Our ref: EF19/18621

Proposal: Central Coast Leagues Club redevelopment

Panel Meeting: 27/08/2019

Attachment A – Design Review Panel Advice

TOWER LOCATION

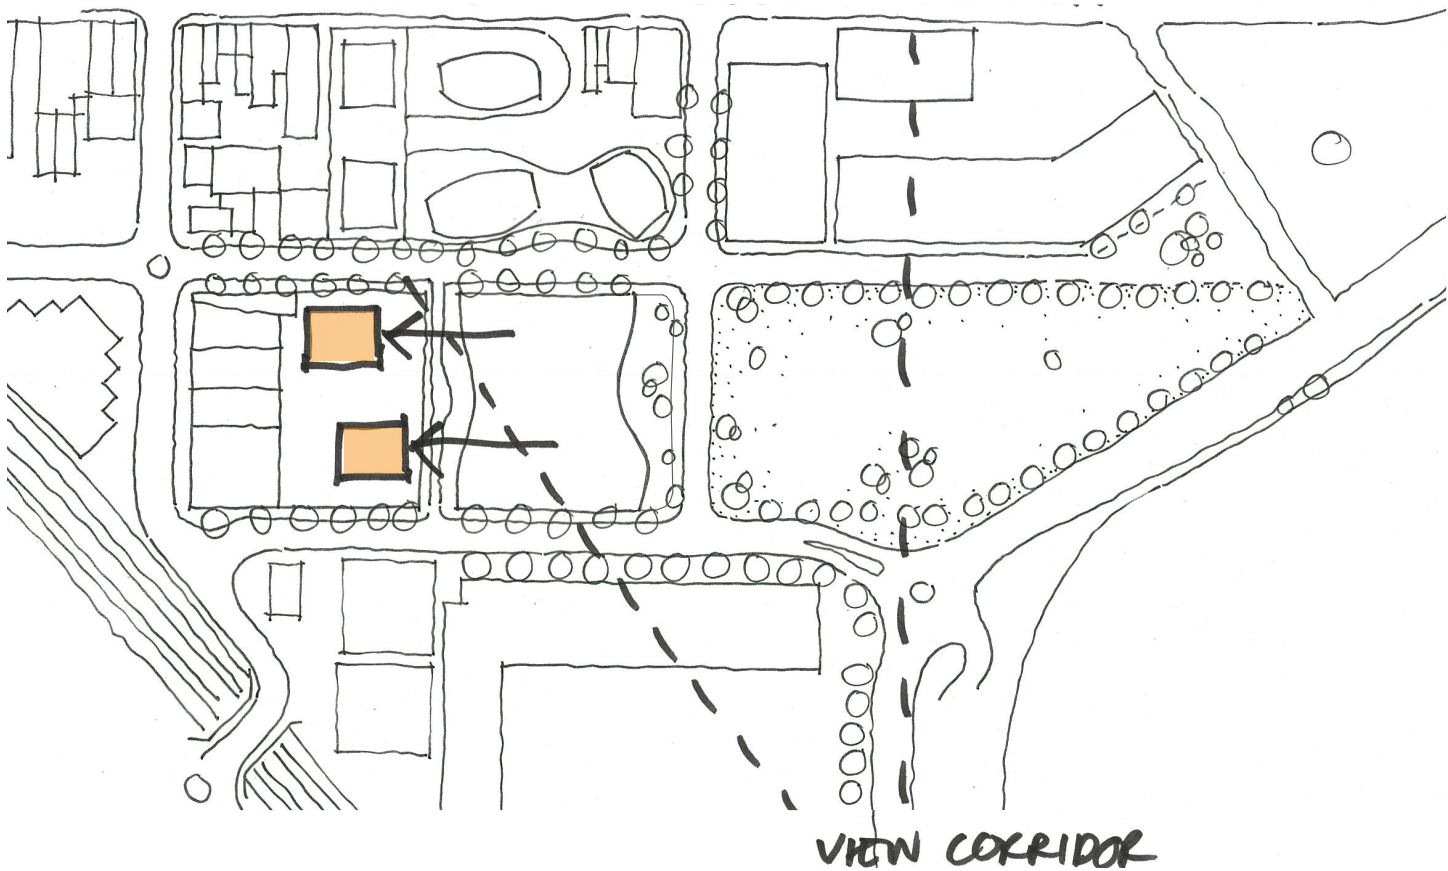
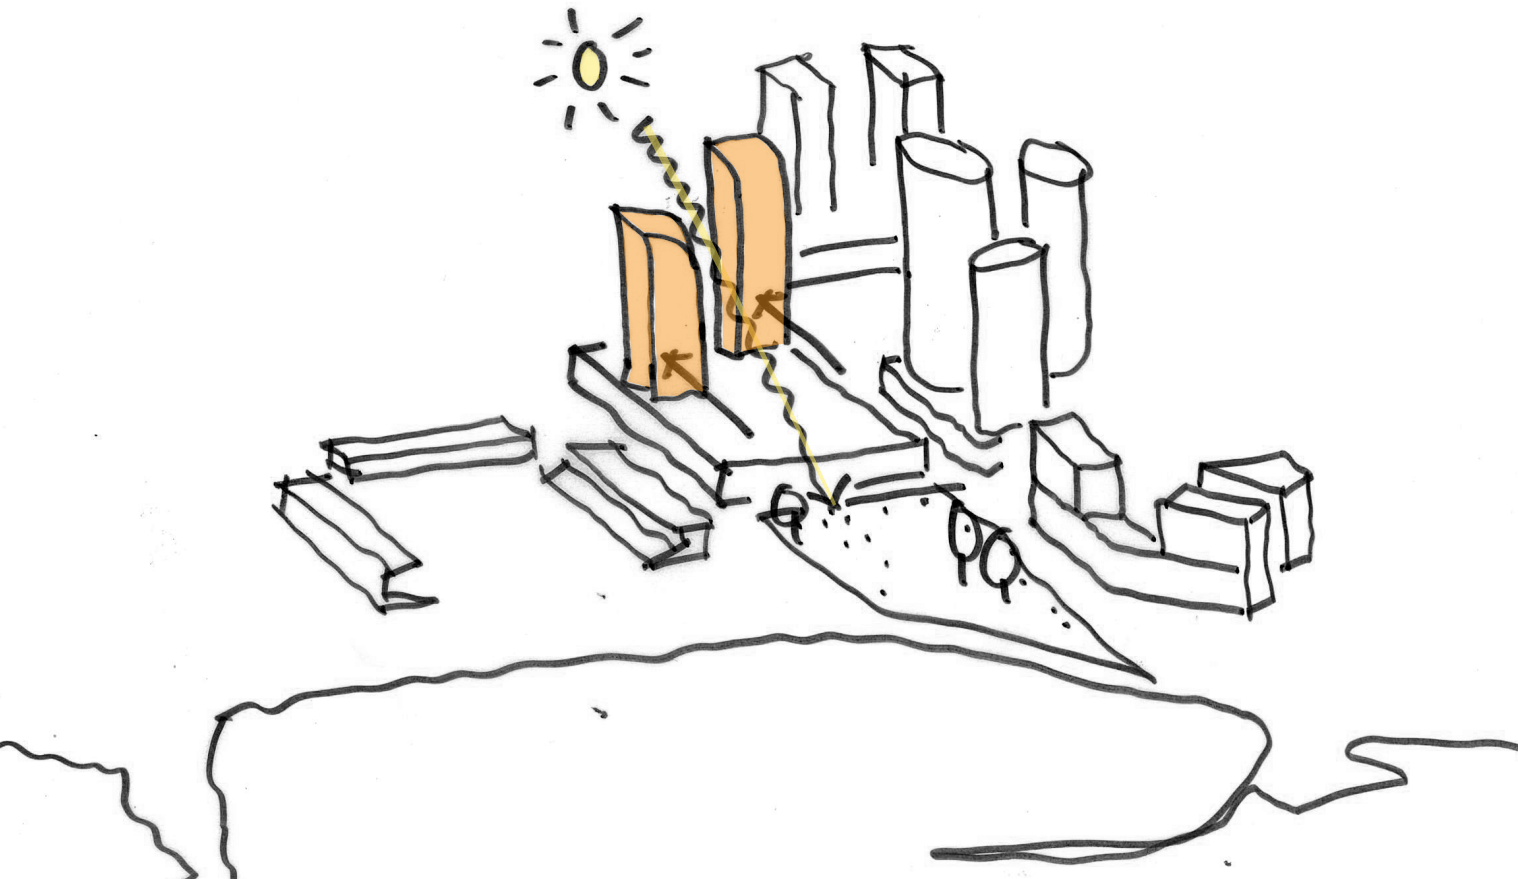
- The Panel raised concern about the current proposed height of the towers in relation to visual impact, variation in heights, providing a transition down in height from the more intensely developed city centre to surrounding areas and overshadowing of open space.

- The Panel recommended the proponent:
 - Reduce the height of the western tower to allow the towers to be more easily distinguished e.g. Applying a 15% 'rule of thumb' height variation between the two towers

- Amend the design, orientation and form of the towers to provide a transition of tower heights towards the edges of the site and provide greater variation in the design

PRIVATE OPEN SPACE

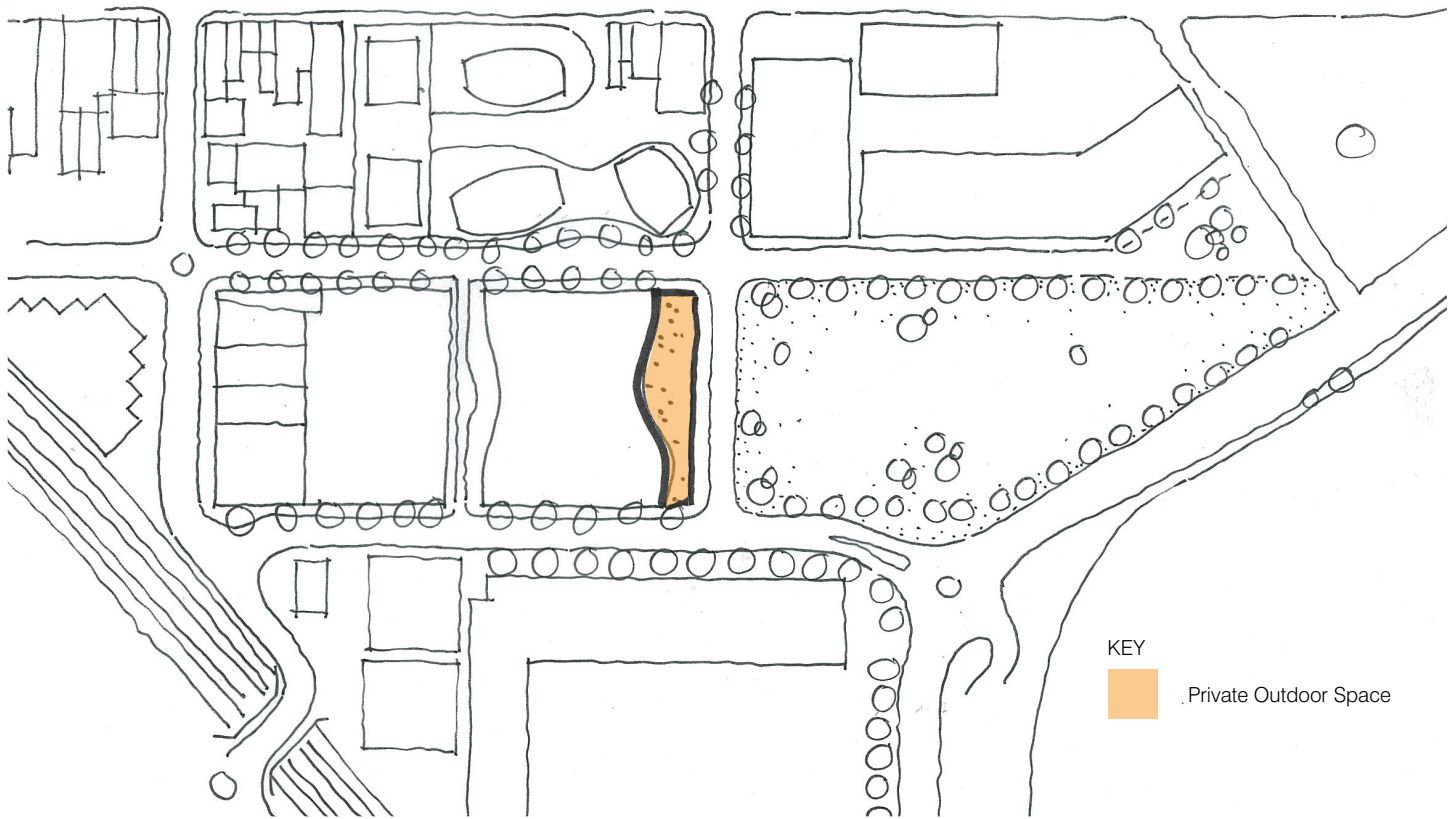
4. Georgiana Terrace / Frontage to Leagues Club Field
 - The Panel made the following comments on the proposed private open space along Georgiana Terrace:

- There is a need for activation long Georgiana Terrace, and the final design should include a series of different uses and experiences along this frontage to avoid the appearance of a convention centre

- The relationship to Leagues Club Field is important and the final plans for its redevelopment should be considered in the Leagues Club's design and treatment of the forecourt and pedestrian access points along Georgiana Terrace

THROUGH SITE LINK

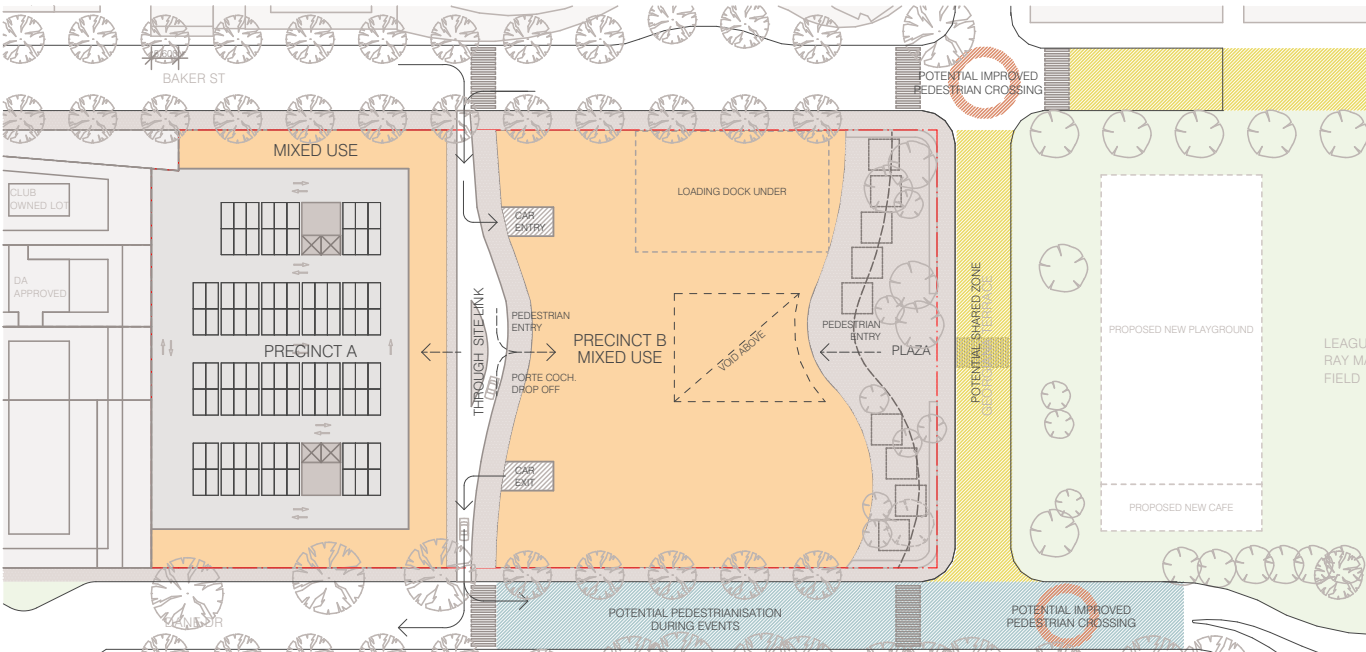
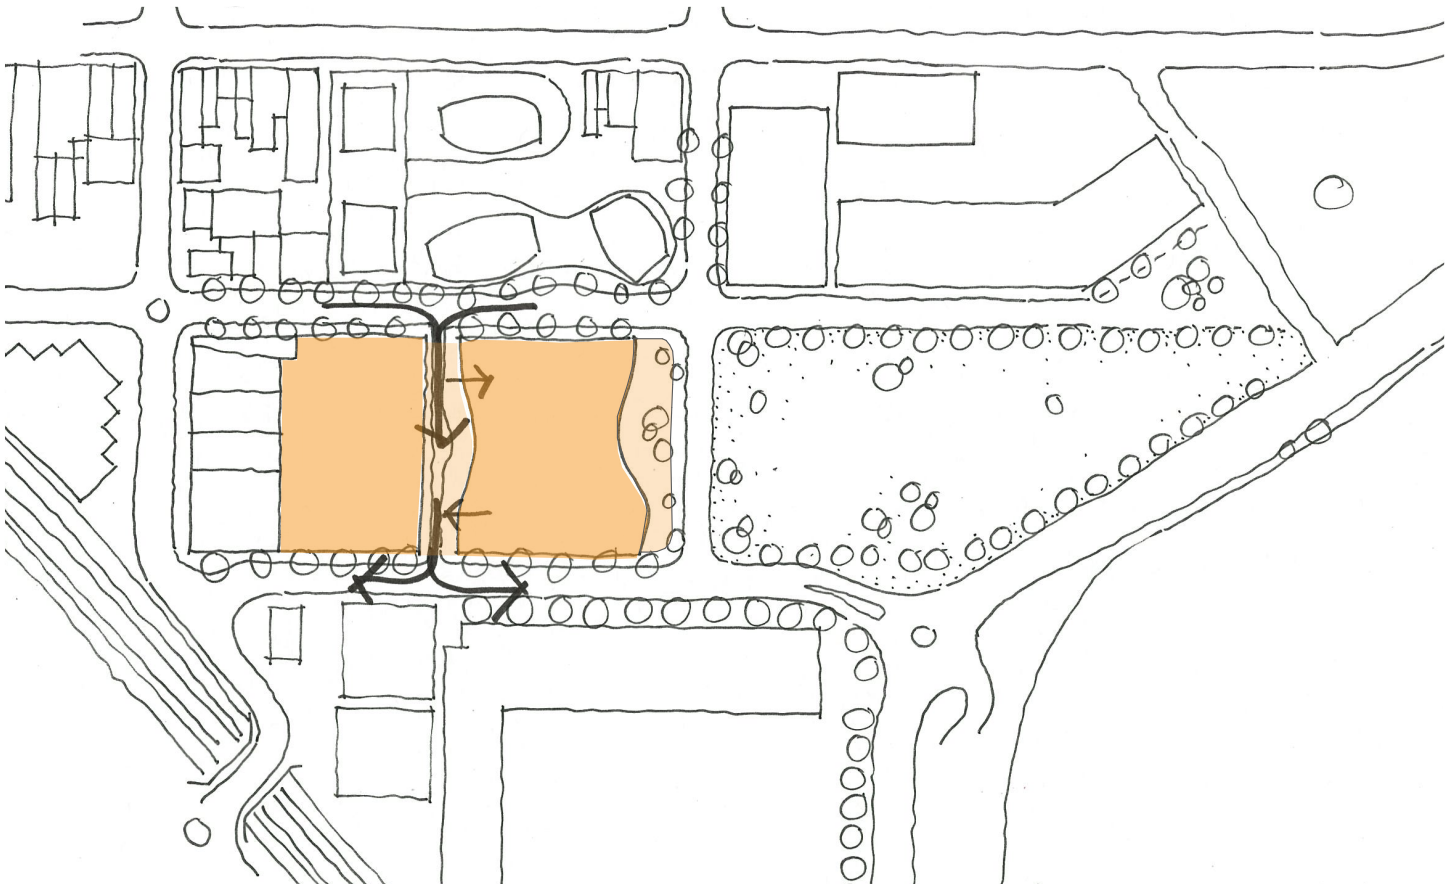
3. Through Site Link
 - The Panel highlighted that the experience of people moving through the through-site link is also important.
 - The Panel noted the concept of a laneway style, shared pedestrian / vehicle space, with active frontages and a mixture of uses currently proposed by the applicant would be positive and noted this type of space in Gosford is untested in Gosford.
